My ref: RLS/18/04/17/Ar

Your ref: A/31/19/PL

8th April 2019

Application for a single Dwelling.
Land North of Ashurst, Plot 9, Ham Manor Way, Angmering.
Planning Application Ref: A/31/19/PL

Elevations (1:100)

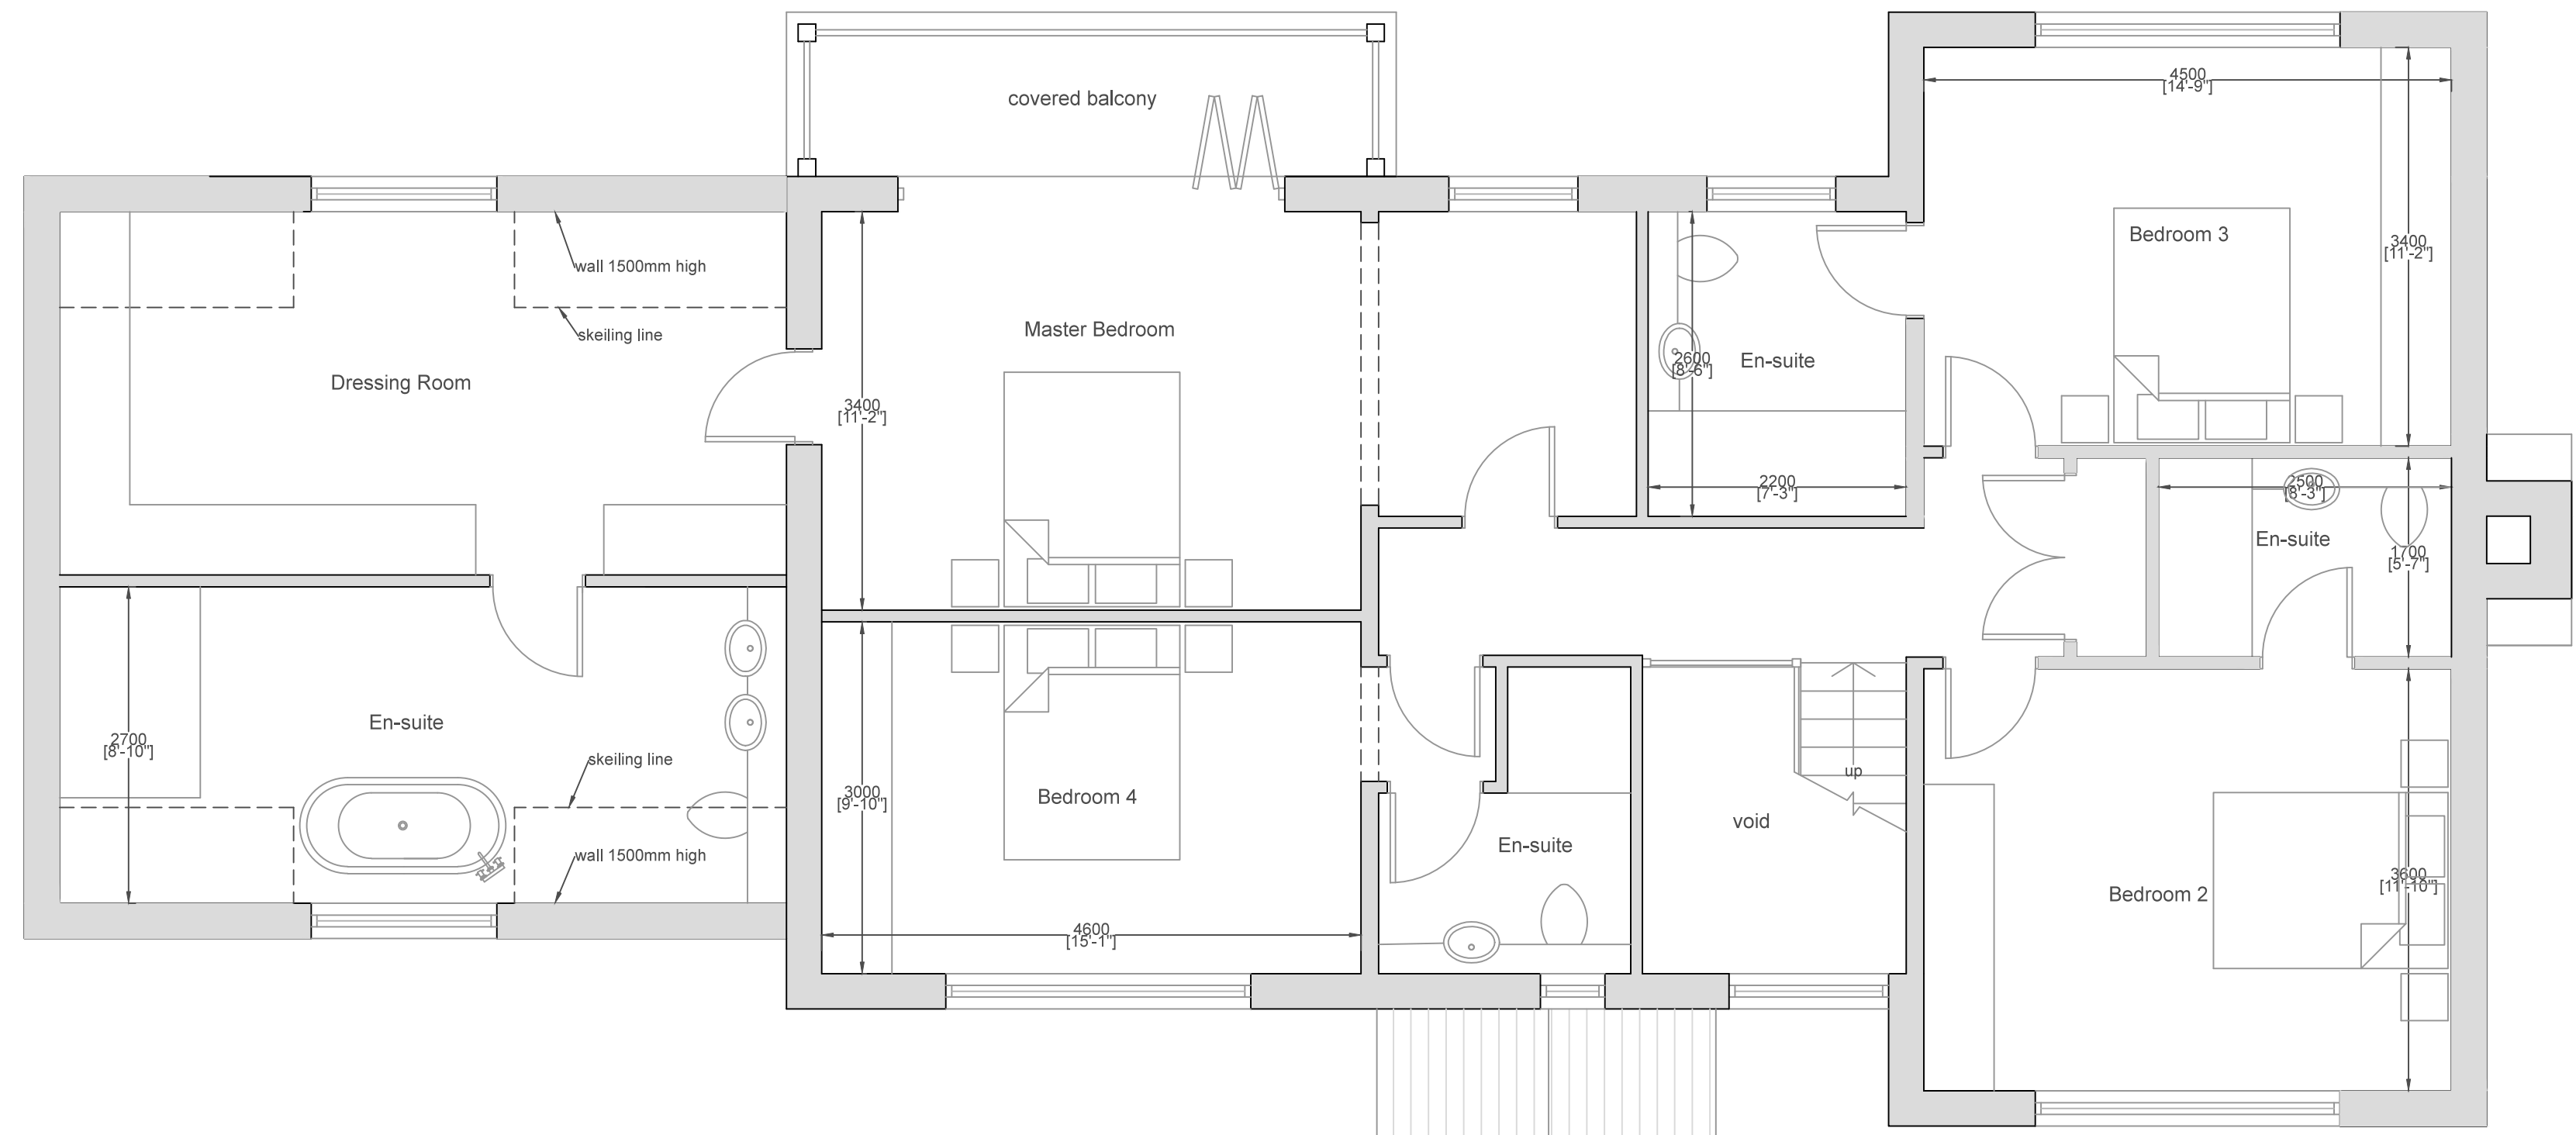
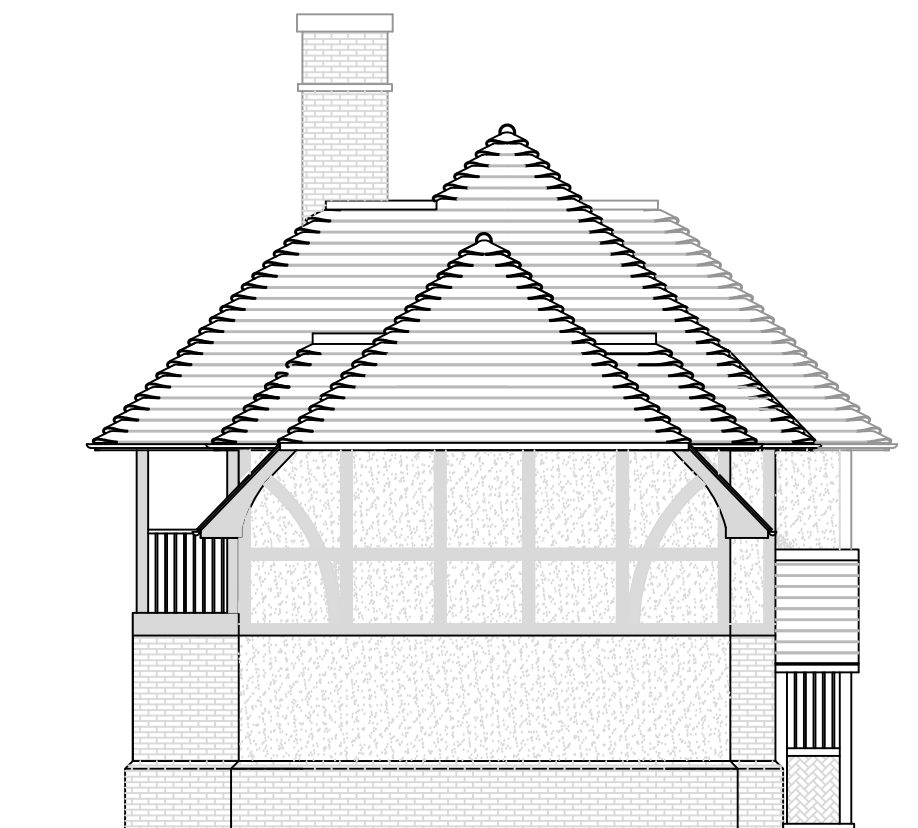
space available where the new chimney has been introduced. On the southside this appears to run into existing ground levels but the ground falls from east to west and this appears to lack certainty as to just what is intended. This situation affirms problems that arise out of the intentions to raise the ground levels within what is a very mixed level of ground with changes that occurring both from both south to north and east to west.

My next concern is the situation across the frontage of the site. The northern 75% of the building is in full two storey height, whilst the south section of this frontage is shown at 1 1/2 storey height to eaves level. In assessing the impact of the front elevation this is clearly further forward, both of Ashurst to the south and Badgers to the north. This is not helped at all by the submitted block plan being well out of date and not showing the more recent changes to Ashurst to the south. The consequence of all of this is that the building now appears more prominent being closer to the highway, with no verges shown across the existing frontage of the site. My view is that the front elevation now needs to be set back, as a matter of principle regardless of the design and aspect of the building, with the correct distance also shown for the depth of the rear elevation to the common rear boundary. As it stands this dwelling is now totally out of character in terms of the full impact of the frontage of the development upon the host environment.

Street Elevation (1:200)

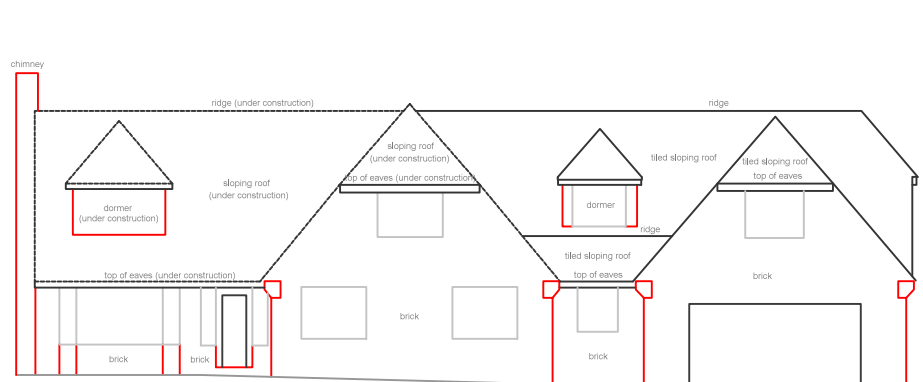
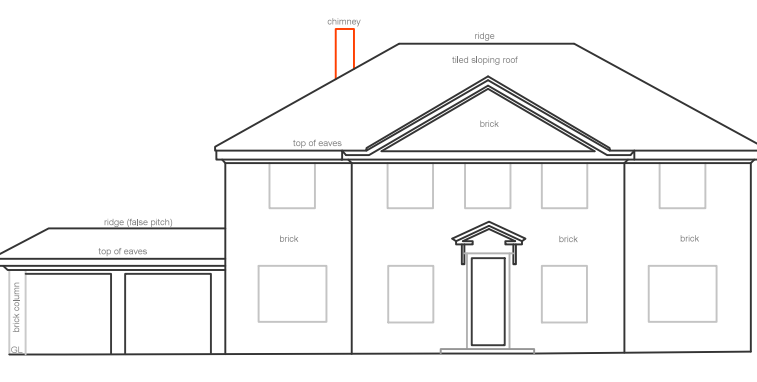
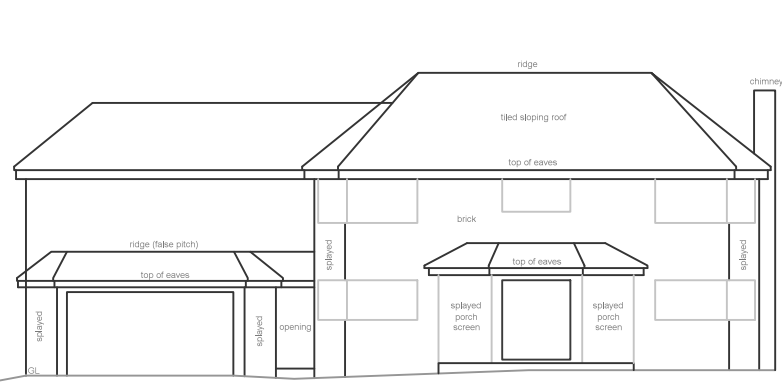
On the unnumbered page 4, (scale), it is a matter of fact that the dwelling is taller than Ashurst and more importantly all of the neighbouring properties opposite the site. There is nothing shown within the submitted plans to in anyway hide the dwelling from its location and in this respect with no apparent screening available the perceptive height of the building will always be read in connection with the dwellings opposite and with Ashurst to the south.
